Lower Thames Crossing

5.4.4.11 Draft Agreed Statement of Common Ground between (1) National Highways and (2) Transport for London (Tracked changes version)

Planning Inspectorate Scheme Ref: TR010032
Application Document Ref: TR010032/APP/5.4.4.11

Drawing file: TR010032 / TR010032-005281-Additional Submission - Land Plan - v6 Deadline 5 - Sheet 45 - Visual Aide.pdf

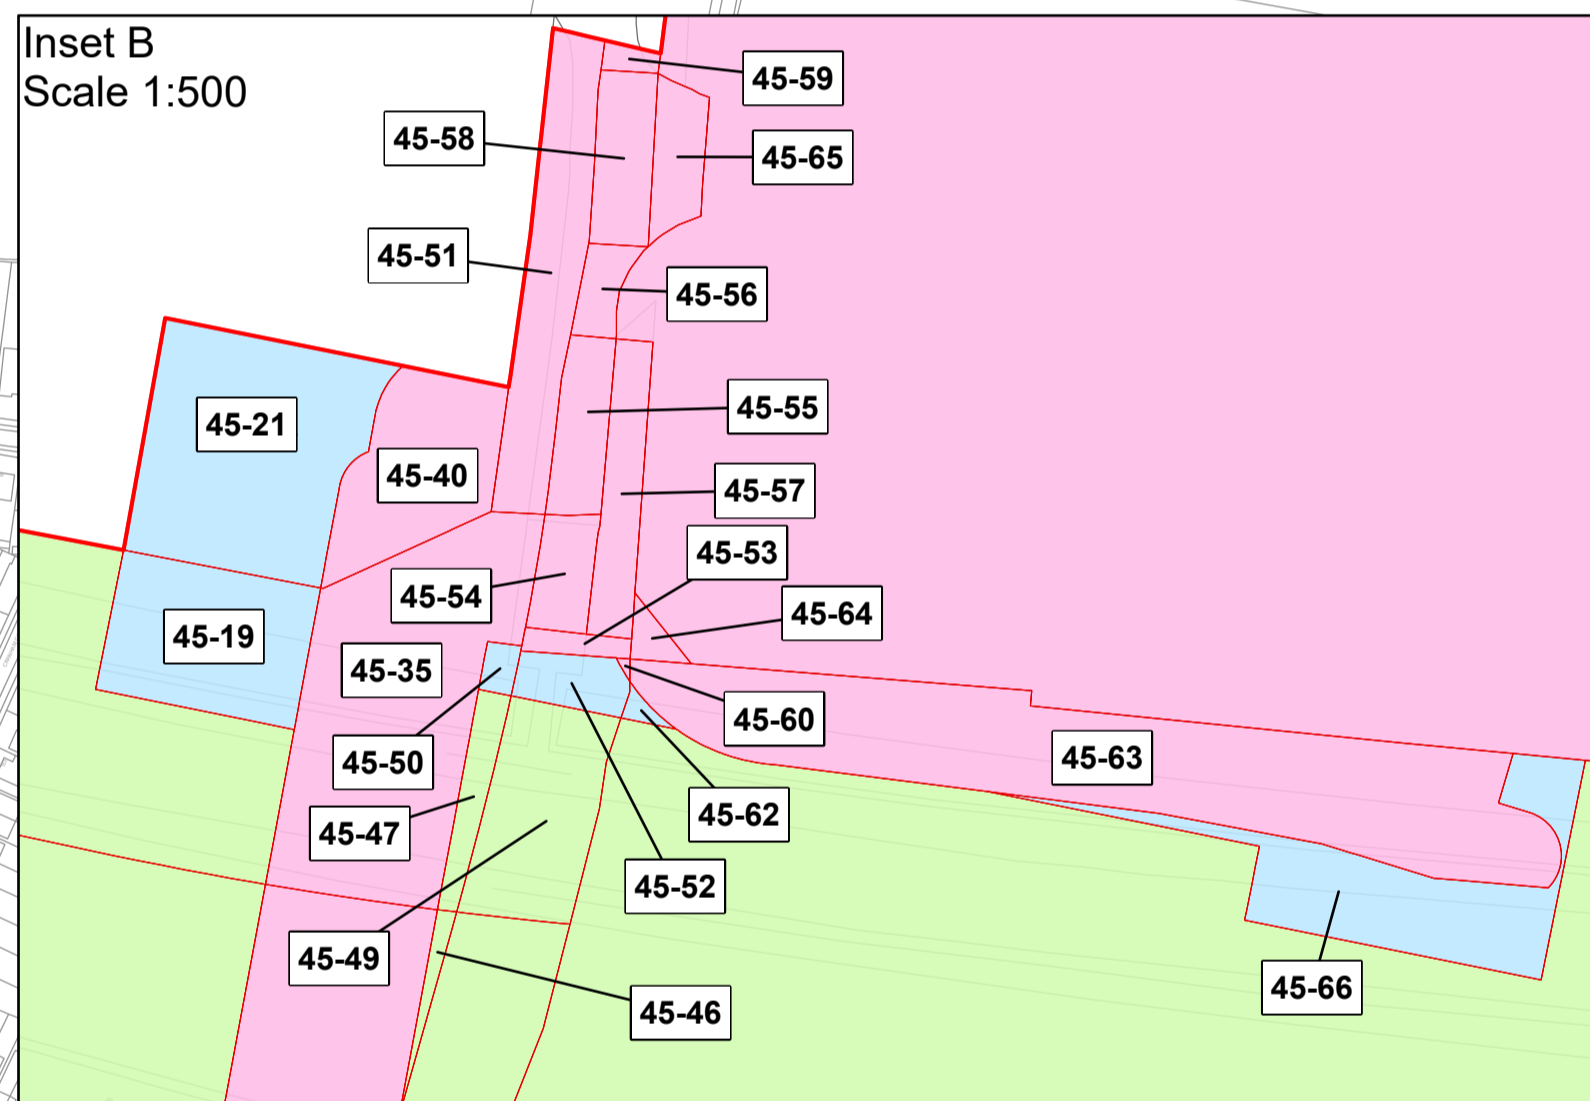
Topic	Item No.	Transport for London comment	National Highways' Response	Application Document Reference	Status
Land acquisition Permanent vs temporary acquisition	2.1.7 RRE	<p>Transport for London owns the freehold of certain parcels of land within the DCO application boundary around J29 of the M25 and relating to the A127.</p> <p>The Land Plans from the previous application documents shared with Transport for London (October 2020) showed most of the land west of the roundabout within the order limits and the TLRN as it passes the roundabout as permanent acquisition. This would suggest that National Highways intends to take on responsibility for this part of the A127. However, the draft DCO that was submitted shows that National Highways are not intending to reclassify any part of the main carriageway of the A127. Permanent acquisition is therefore not required and the powers sought should be for temporary possession only at most but even those powers should be limited.</p> <p><u>Where the Applicant considers it needs to acquire Transport for London highway land or rights over such land to deliver the Project, Transport for London requires that such land over which Transport for London will remain highway authority should be returned to Transport for London's ownership at no cost following completion of the works. Transport for London raised this matter in its relevant representation where it requested an amendment to the draft DCO, for this provision, but following discussions is now</u></p>	<p>The land use to the west of Junction 29 has been amended to address these concerns and the majority of Transport for London's titles are now temporary use. There remain some areas where the Project requires temporary possession of land with the permanent acquisition of new rights for the diversion of utilities. Permanent acquisition of land is also required for a small section of route alignment and for the construction of the new walking, cycling and horse riding (WCH) bridge structure to the west of Junction 29. It is agreed that the Applicant and Transport for London will progress discussions to return any permanently acquired land to Transport for London post construction, including the proposed WCH structure which Transport for London shall be responsible for maintaining.</p>	Sheets 45 & 46 of the Land Plans [Additional Submission AS-010]	Matter Under Discussion
